Thank you for your email forwarding Council's final comments regarding the Nadine Street S75W, dated 14 March 2017.

Road Reserve Width

M:\Projects\20000\26522\Drawings\26522-406-TREES RETAINED.dwg

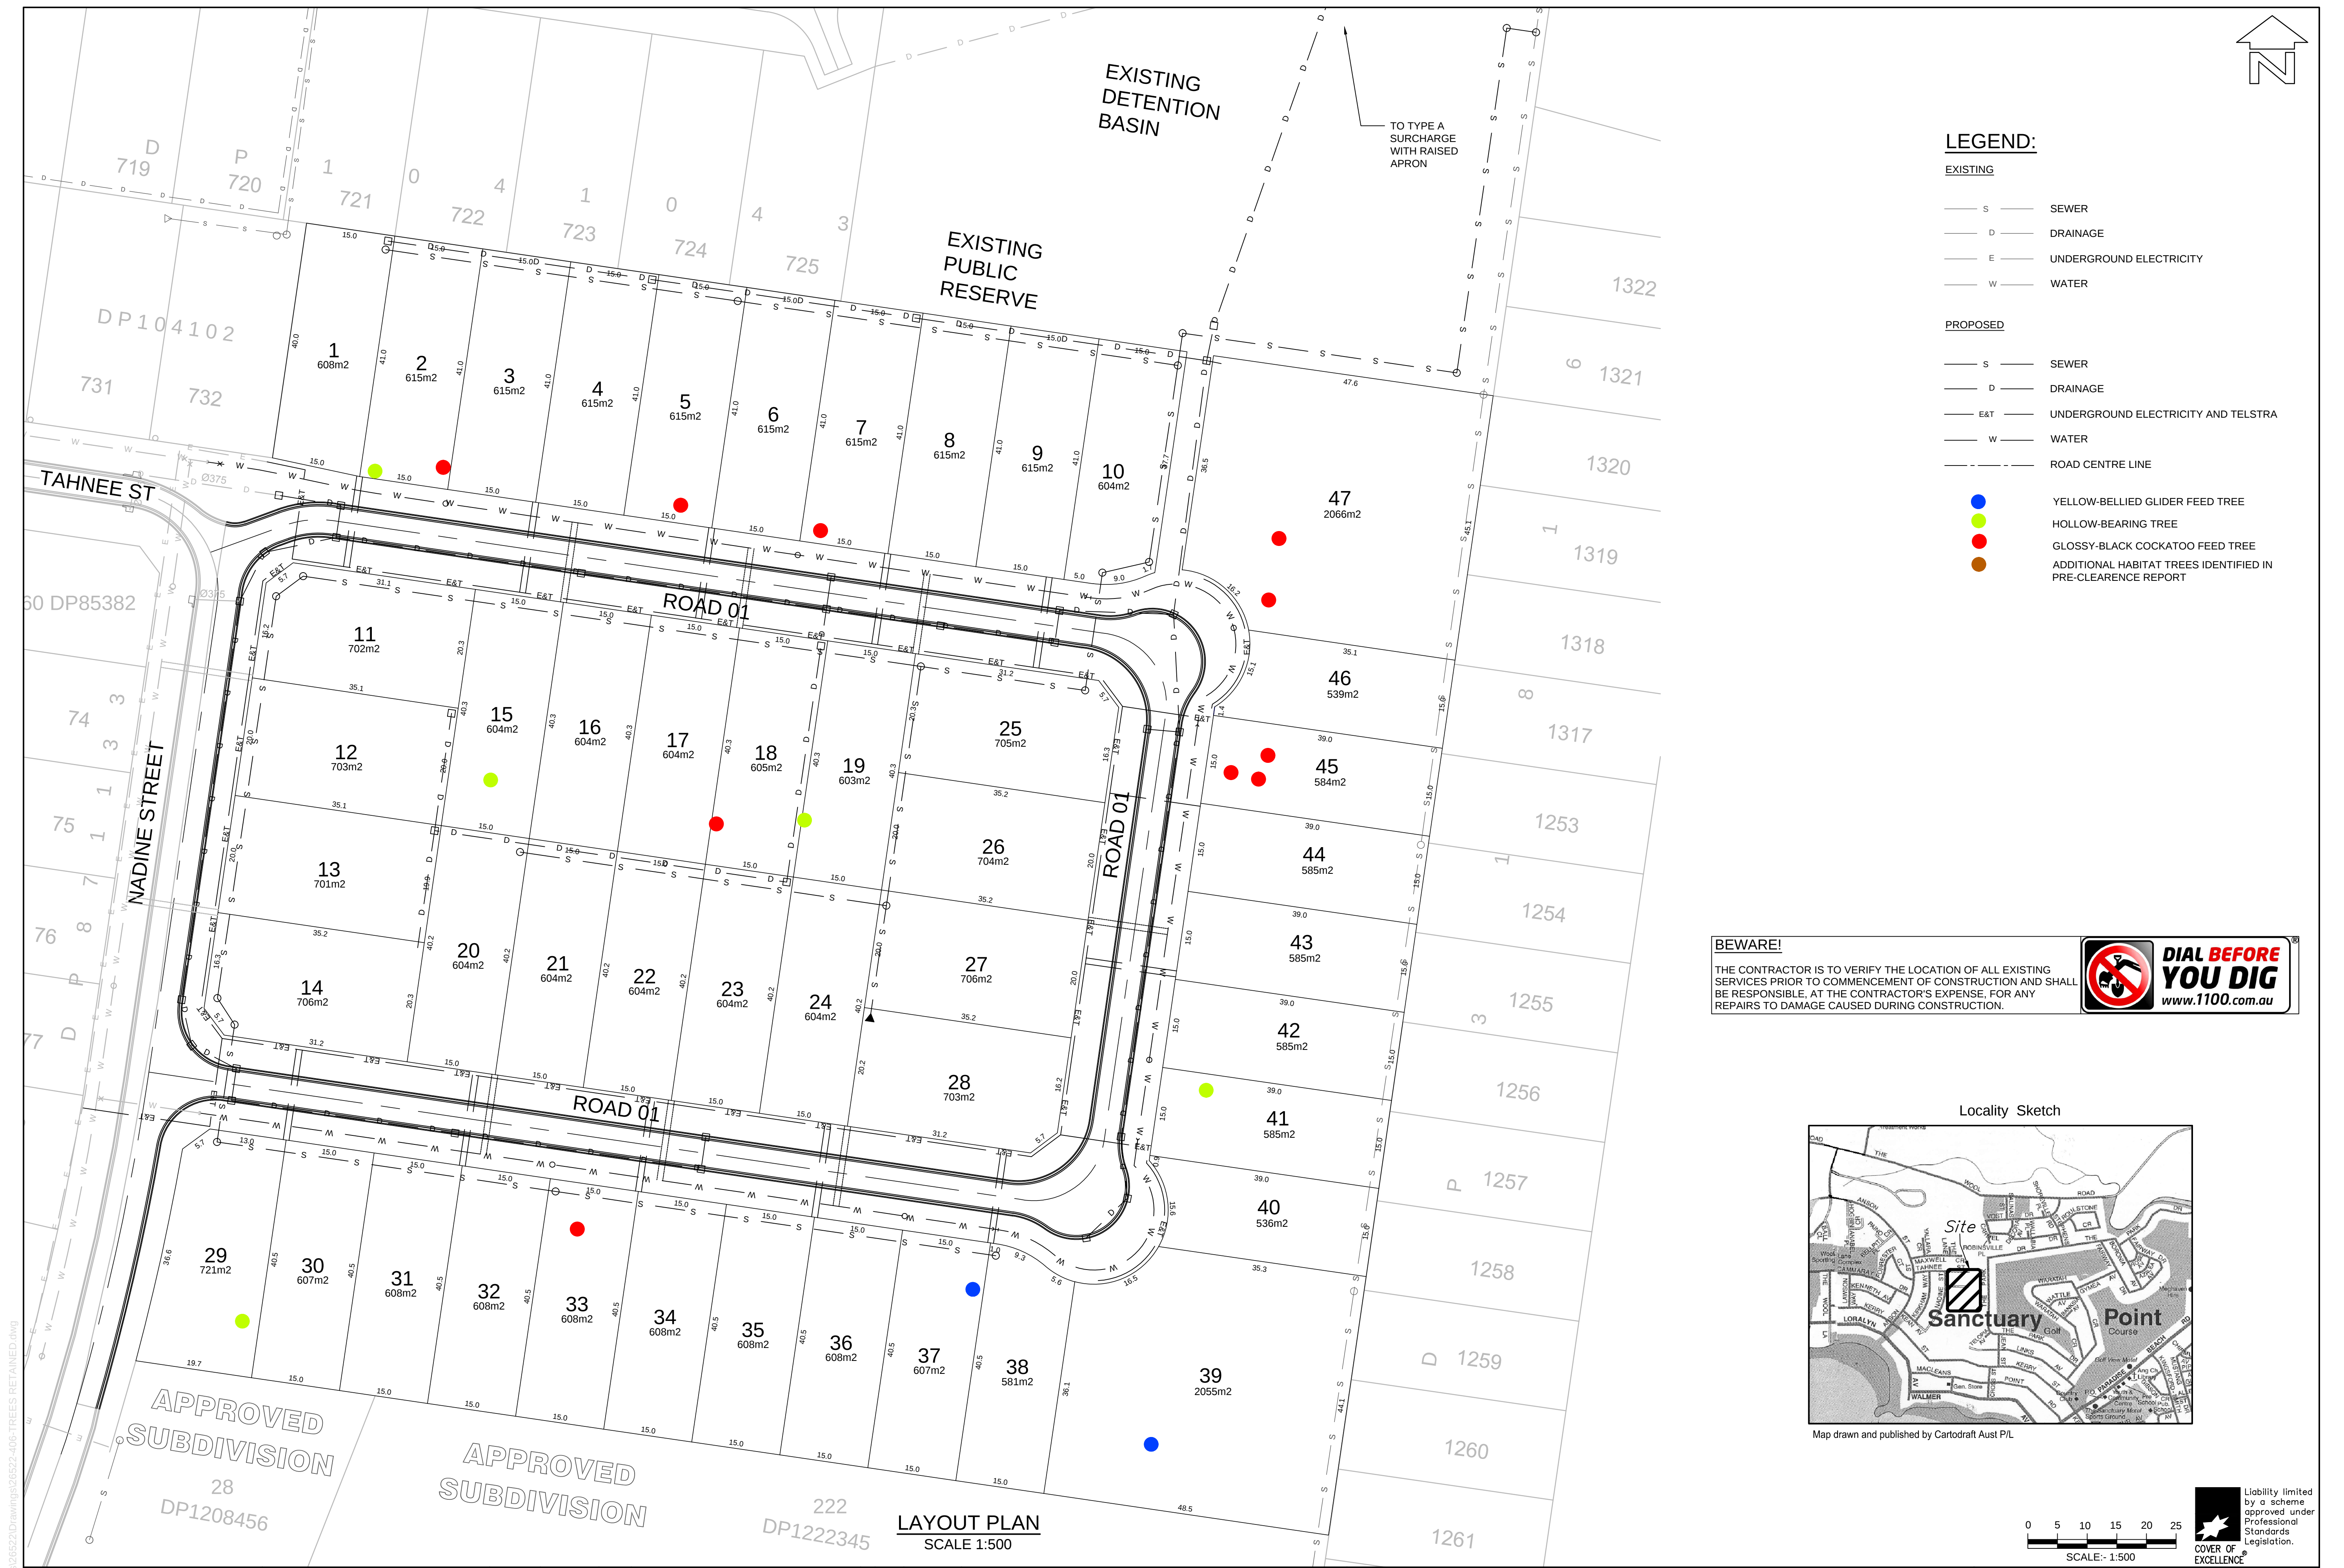
Vegetation Removal

As previously stated, no further clearing is proposed as a result of this S75W Modification, as such there is no additional assessment of impacts required. Conditions of consent provide protection to trees remaining.
